FG/87/21/PL

Tudor Close Ferringham Lane Ferring BN12 5NQ

1 No. new unit in roof space plus reconfiguration of approved dwellings & other changes including retention of flat roof extensions and new dormers to courtyard elevation (revised application further to permission granted under FG/105/20/PL).

Elevations
As Proposed

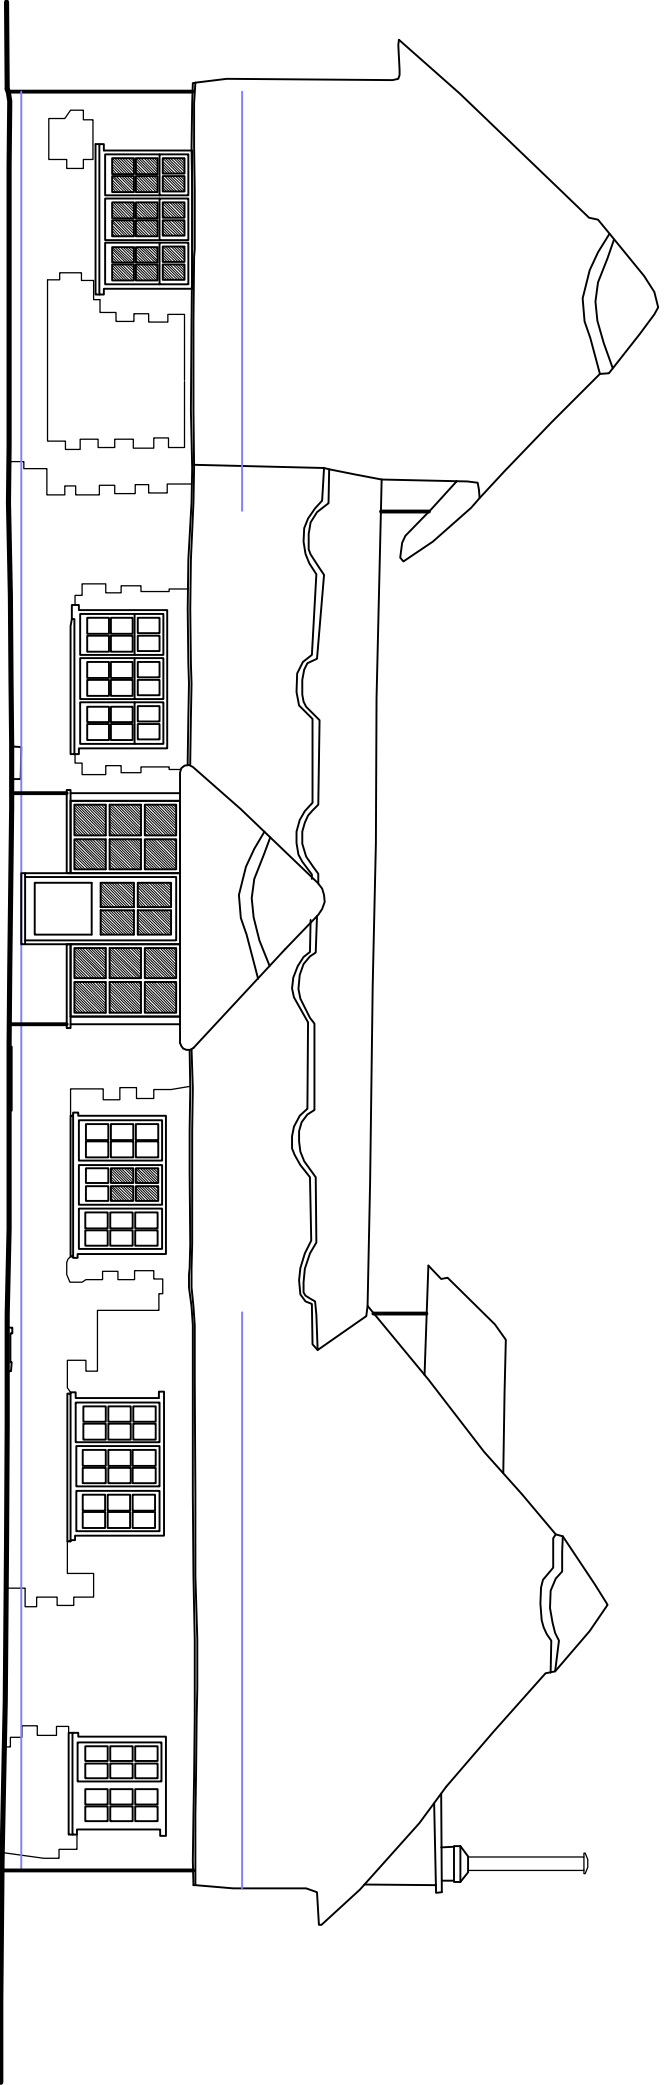
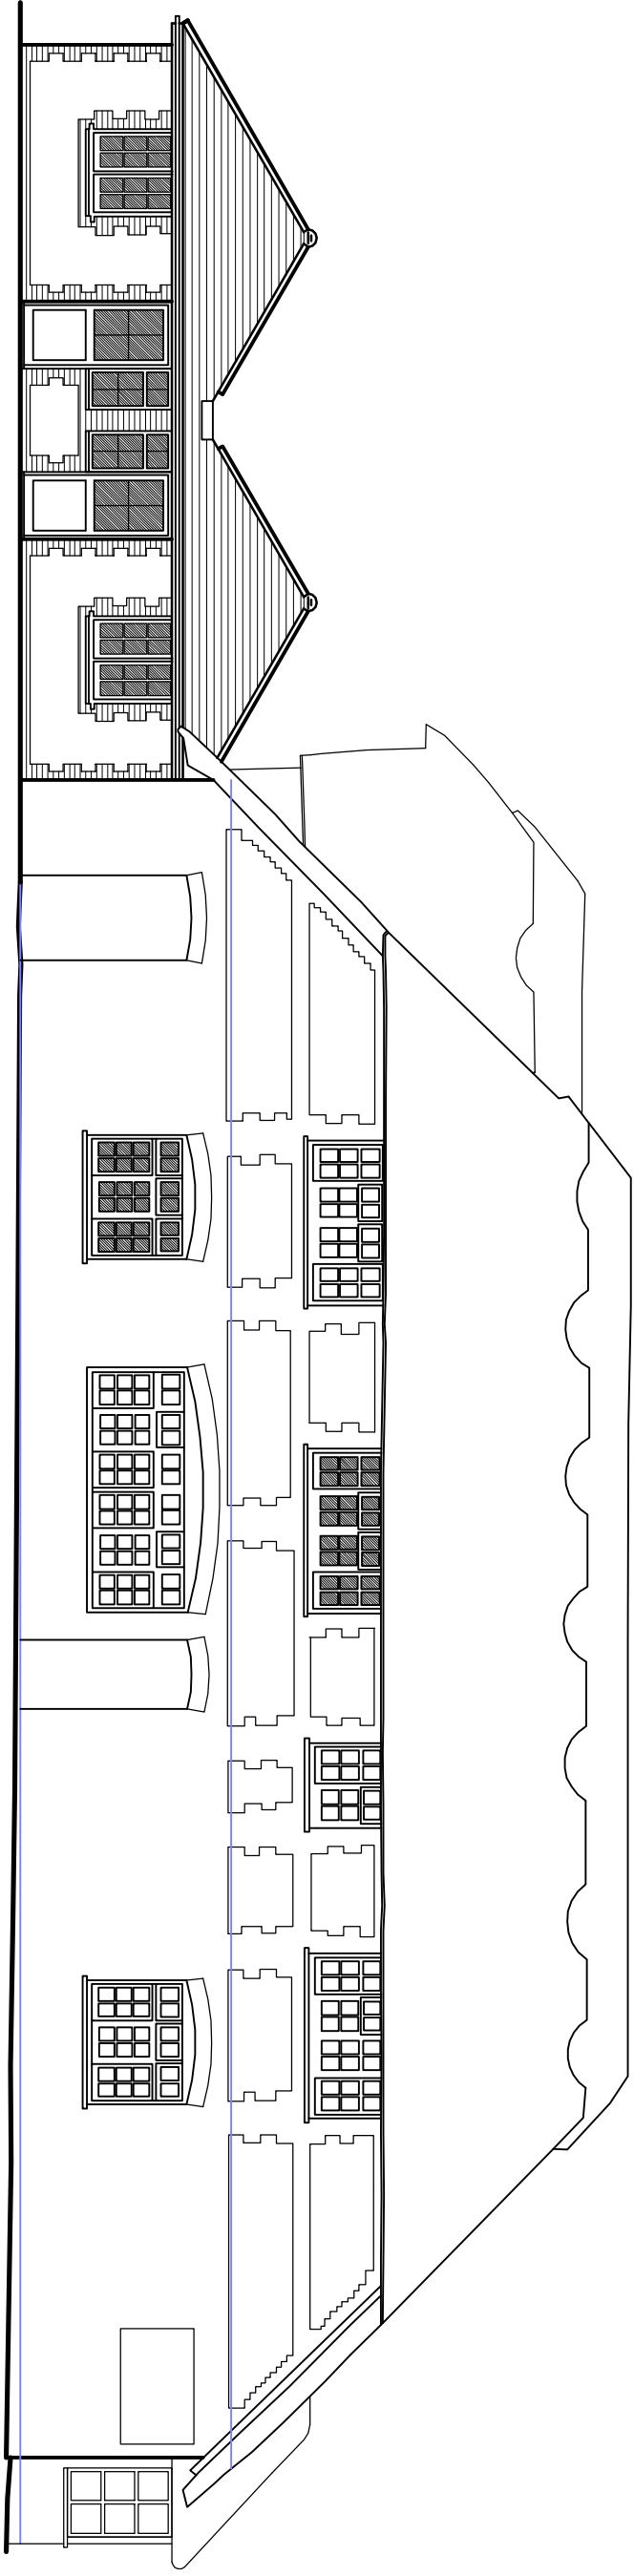
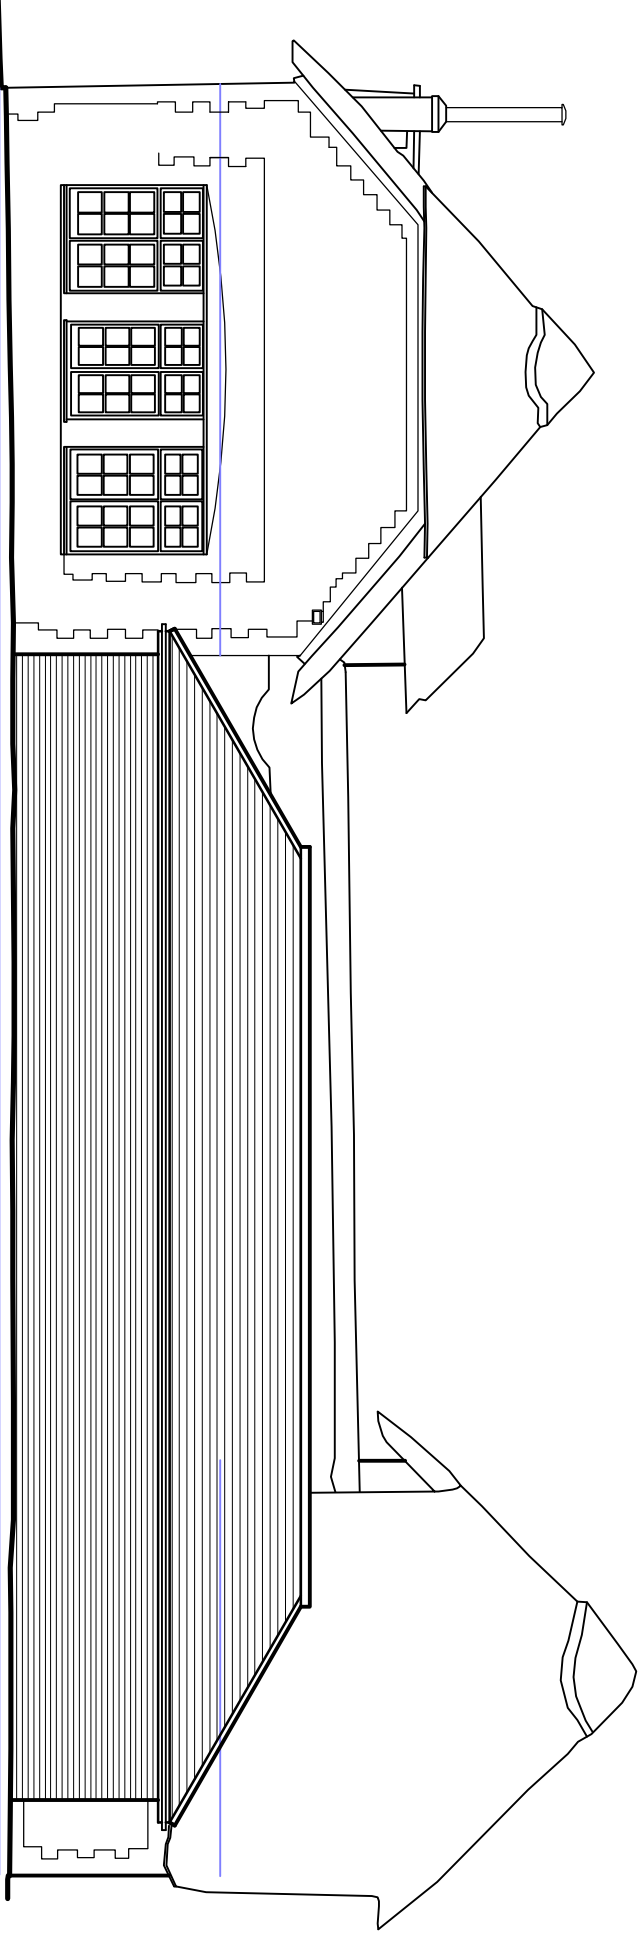
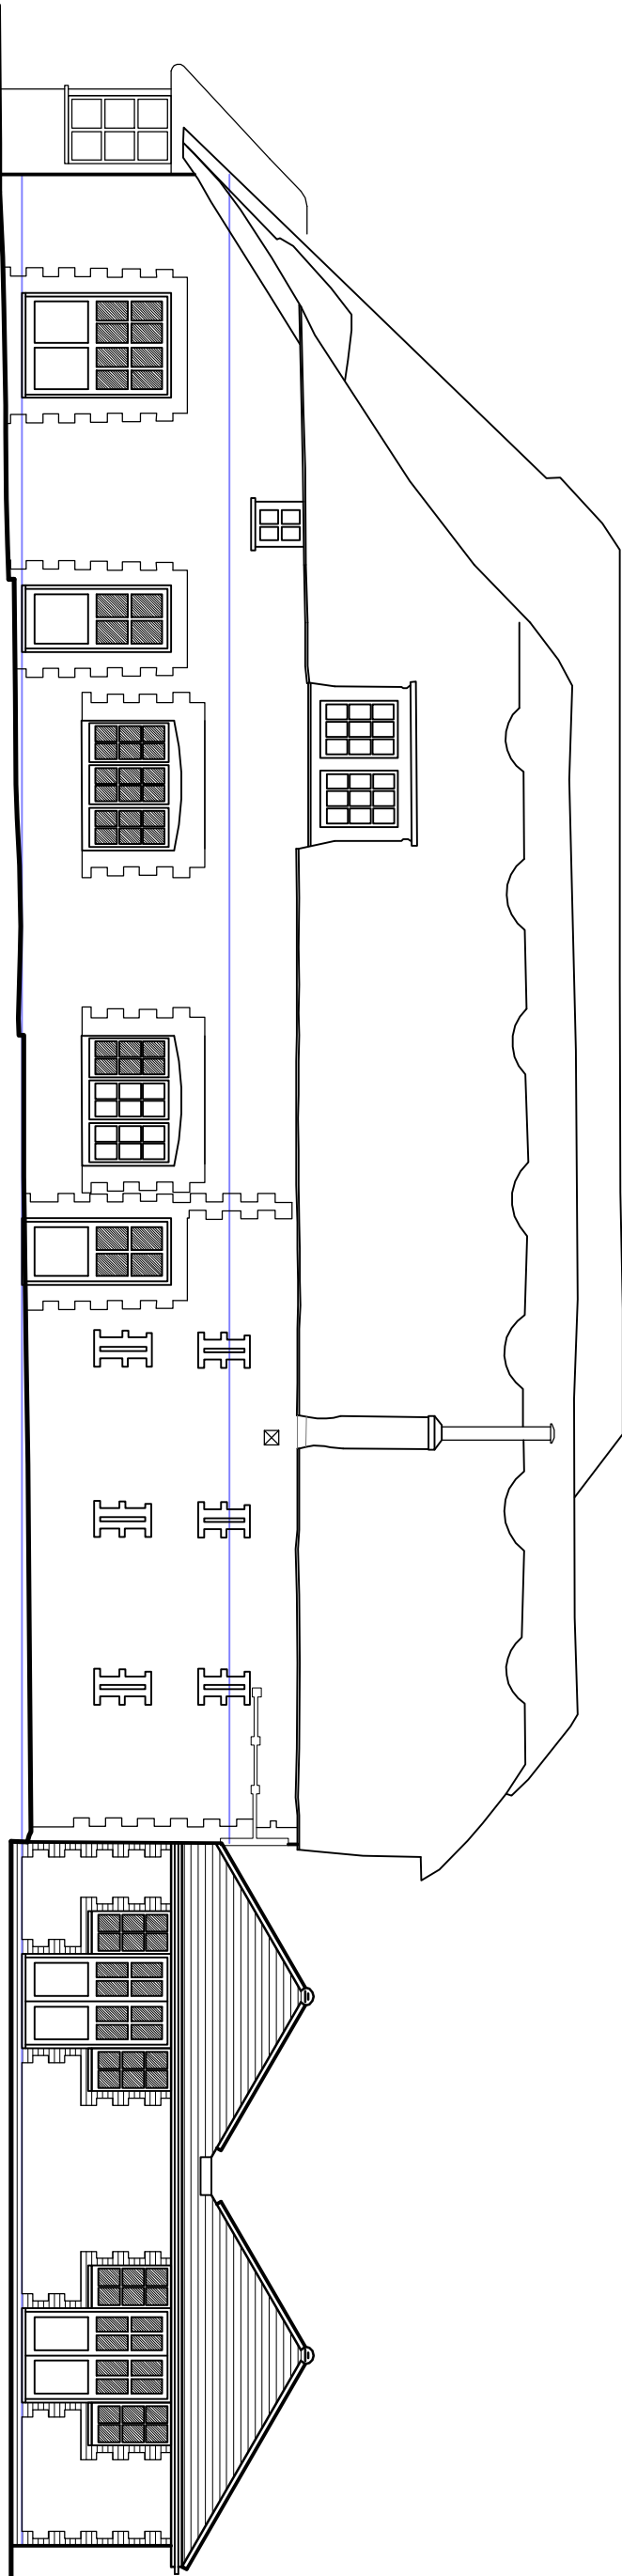
The introduction of further fenestration, particularly dormers, could potentially increase the domestic appearance of the building and so diminishing its original agricultural character. Whilst reference is made in the heritage statement to the fact this part of the building was altered in the 1940, it also appears to be present on the earlier version of the maps provided. The map based evidence provided as part of the heritage statement suggests that this part of the building was present as far back as the first map of 1875.

The proposed dormers, however, will be placed in the courtyard ensuring they would be not clearly visible from the front elevation. The success of such an proposal will depend upon the materials and joinery details. These should be conditioned if you are minded to approve the application.
